DOC17/392562

Re: Shoalhaven Starches - Modification 13 (MP 06_0228 MOD 13) - Modification of Boilers No. 2, 4, and 6

Attachment A:

FIGURE 6-5 PREDICTED NO₂ 1 HOUR CONCENTRATION, PROPOSED BOILERHOUSE MODIFICATIONS

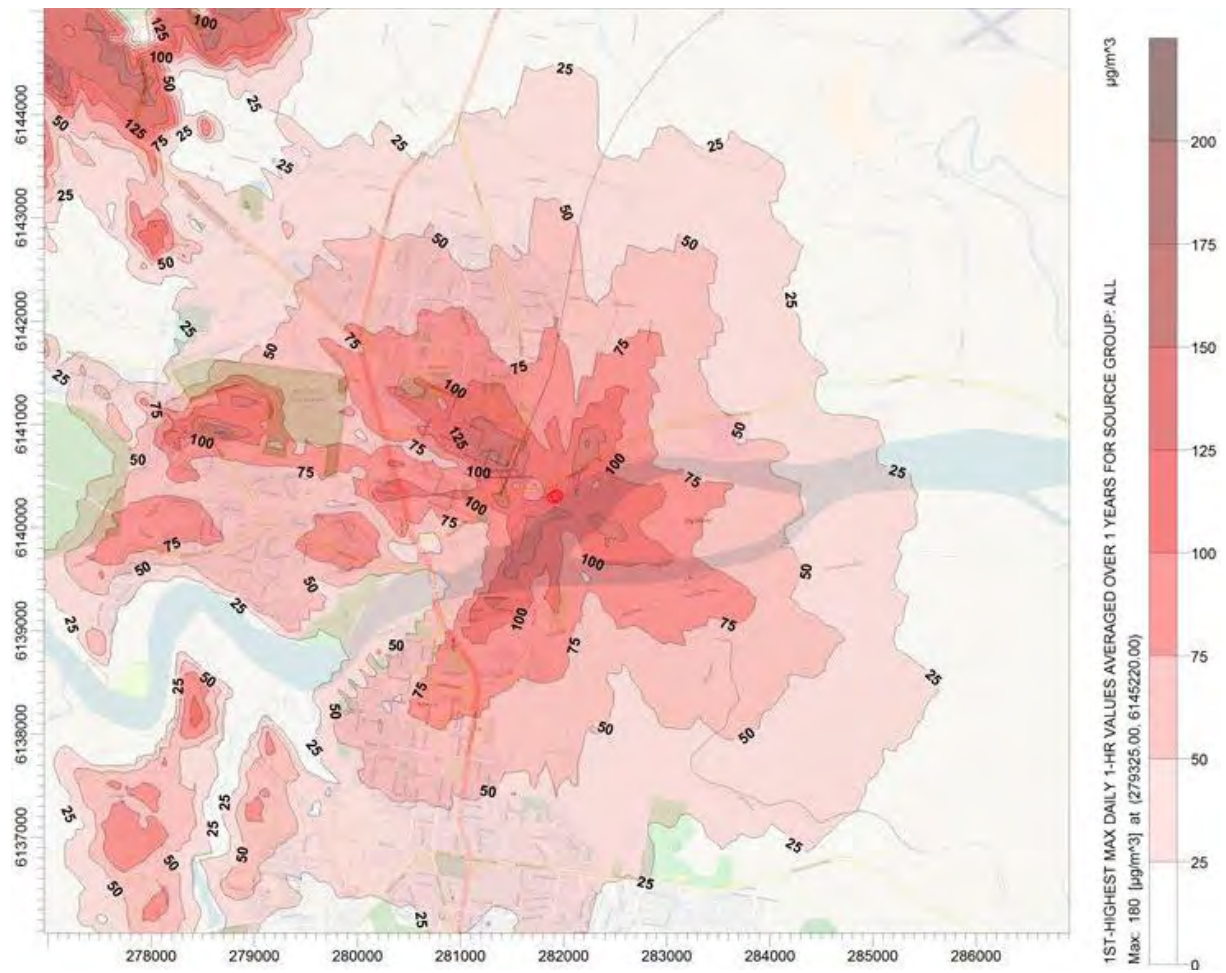
Figure 6-5 and Figure 6-7 in SEMA (2017) are the 1 hour average NO₂ and SO₂ contour plots respectively. It can be seen in both figures that there is an area of maximum impact in the north-west corner that extends beyond the model domain. The model domain must be increased to include all areas of peak impacts.

Recommendation:

The EPA recommends the proponent is requested to revise the model to include a domain which includes all areas of peak impacts.
